Permit Inspections Harnett County

Permit Number: SFD2206-0057

Description: **57x57 sfd, 4 beds**

Site Address: **320 PRINCE PLACE DR**

SECTION 401A SD APA PORTAL FRAME W/ HOLD-DOWNS DETAIL AND APPLICATION BASED ON APA TT-100F WITH USE OF TABLE 1 FOR APA PORTAL FRAME WITH HOLD-DOWN CAPACITIES.

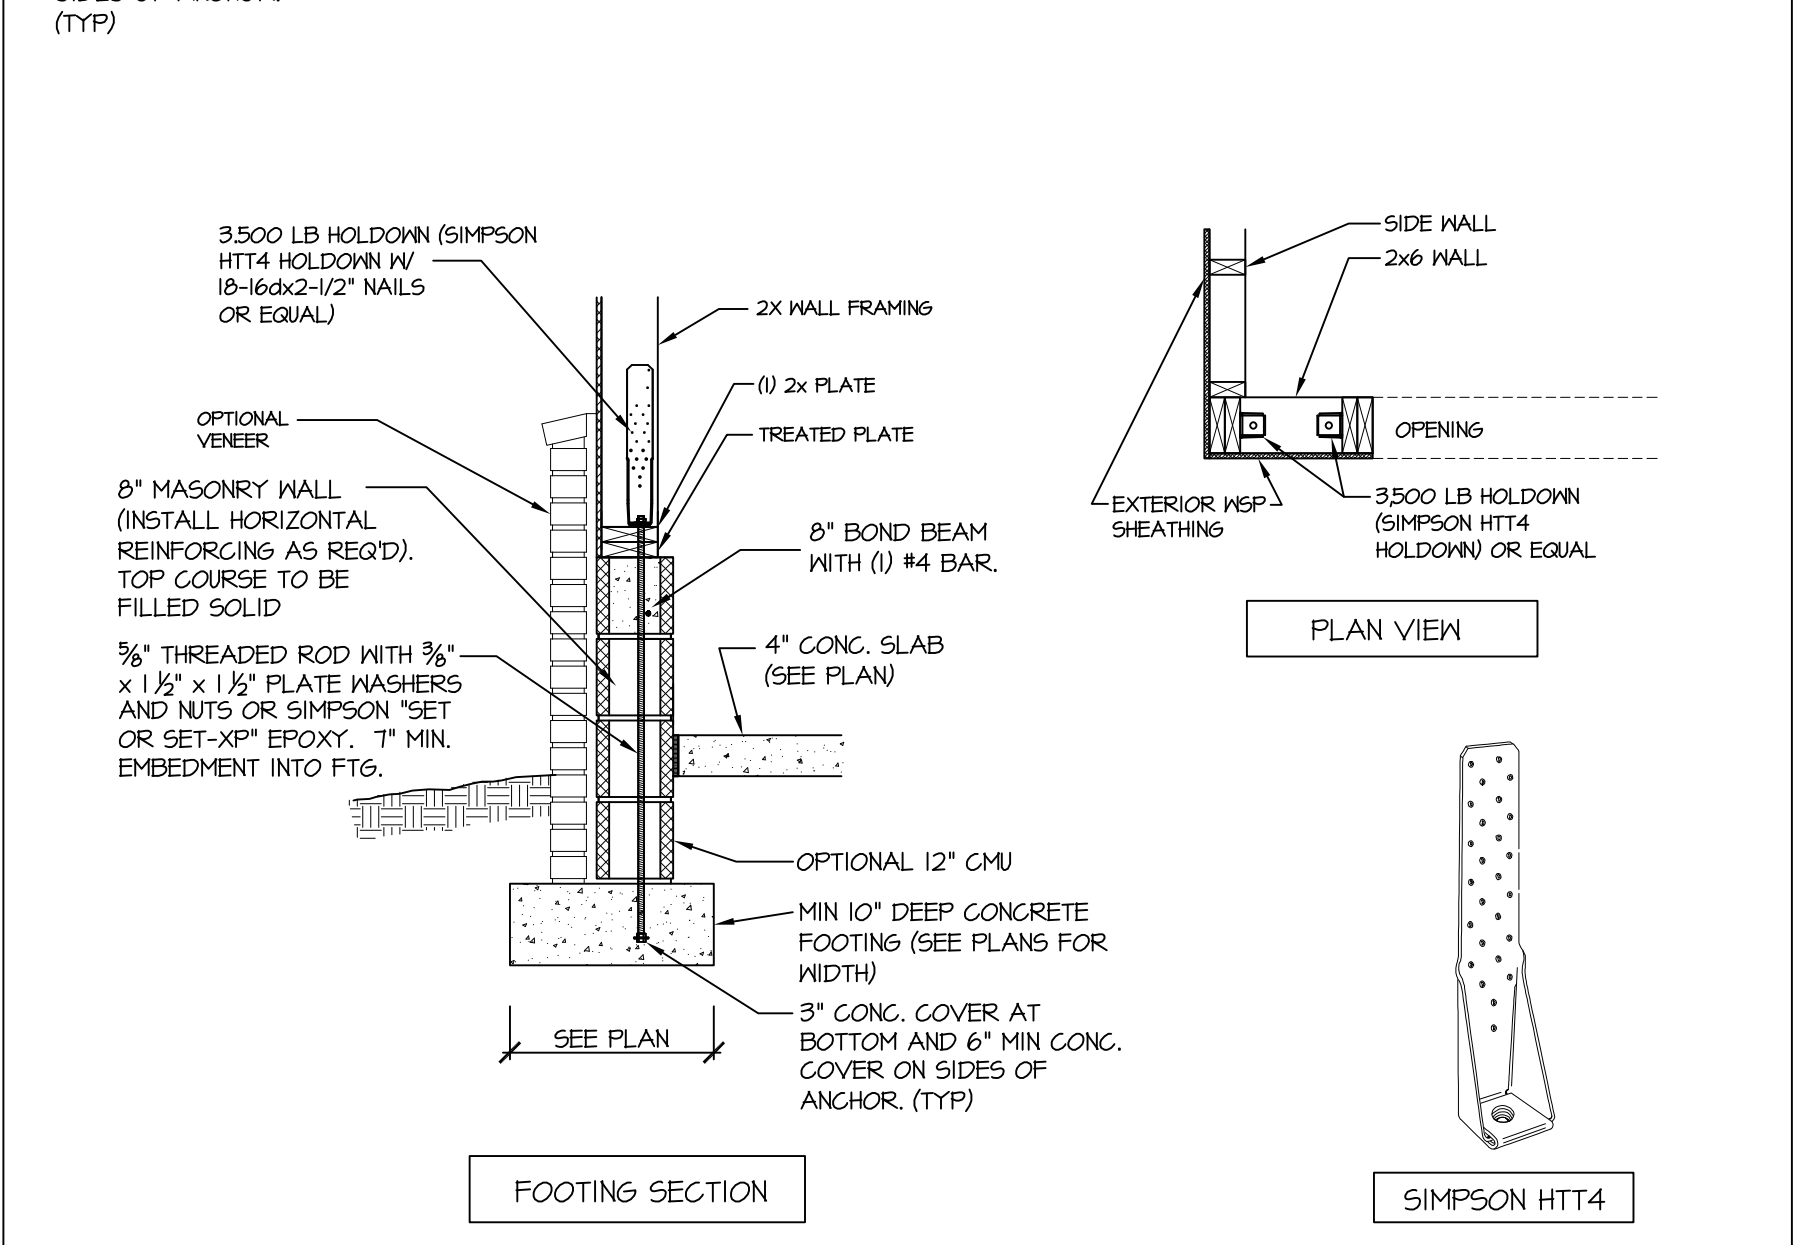
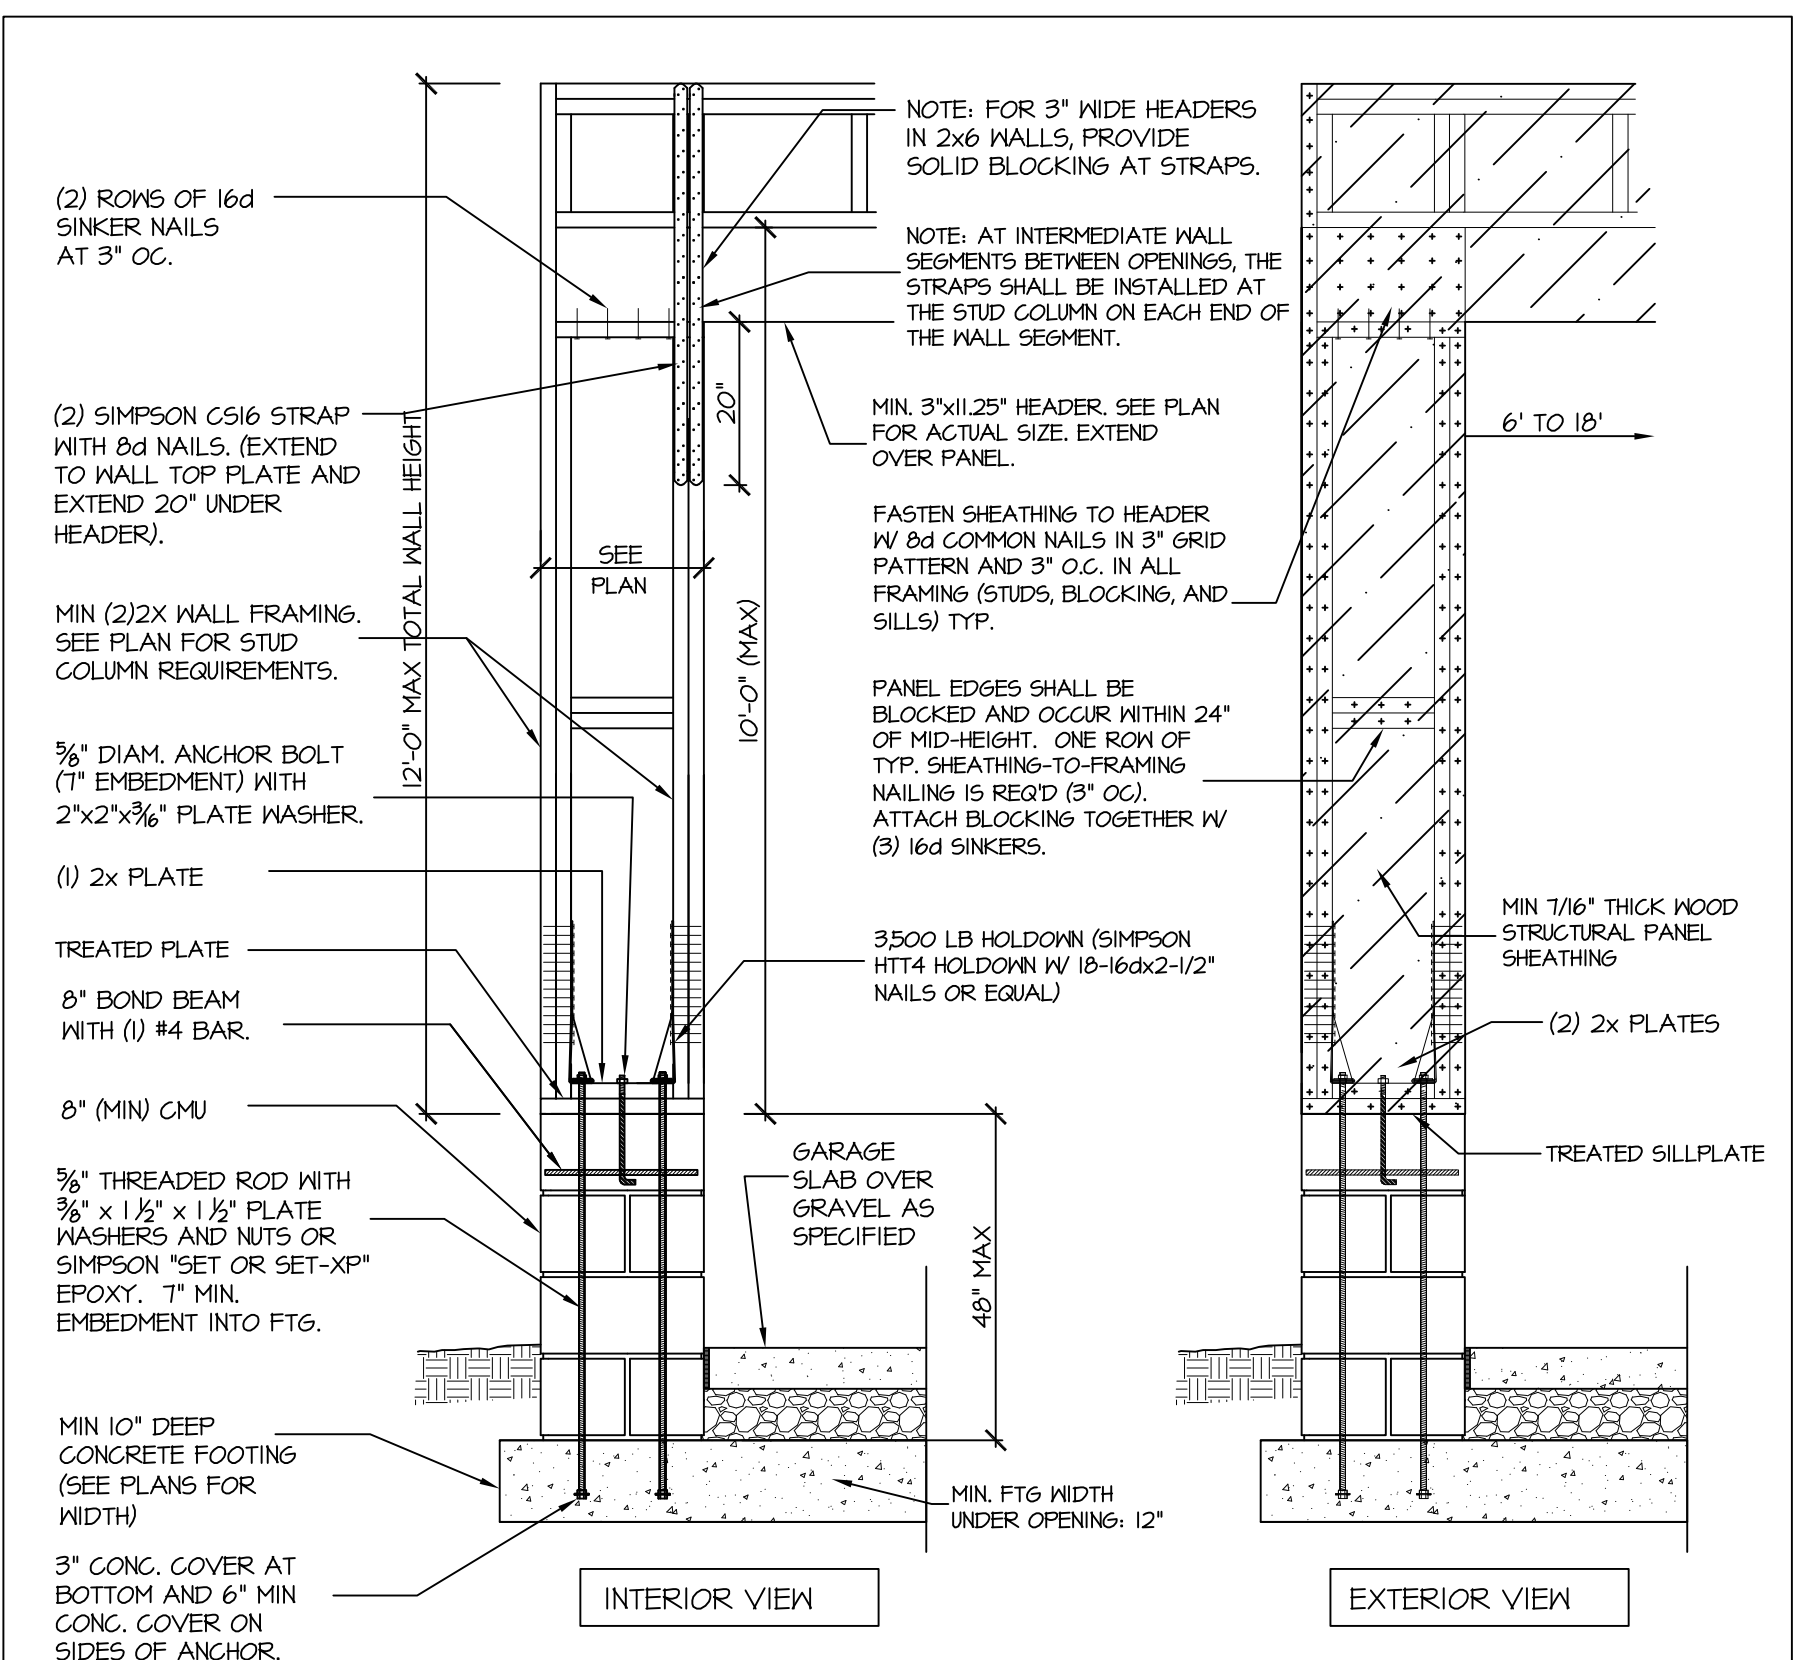
1. Missing htt4 hold down at portal framing per plan. 2. Missing cs16 strapping at portal framing. 3. Missing hurricane clips on 2 rafters above rear door. 4. 3 stud column upstairs right rear bedroom closet area. 5. Plan states knee wall height in bonus to be 4' +/-.
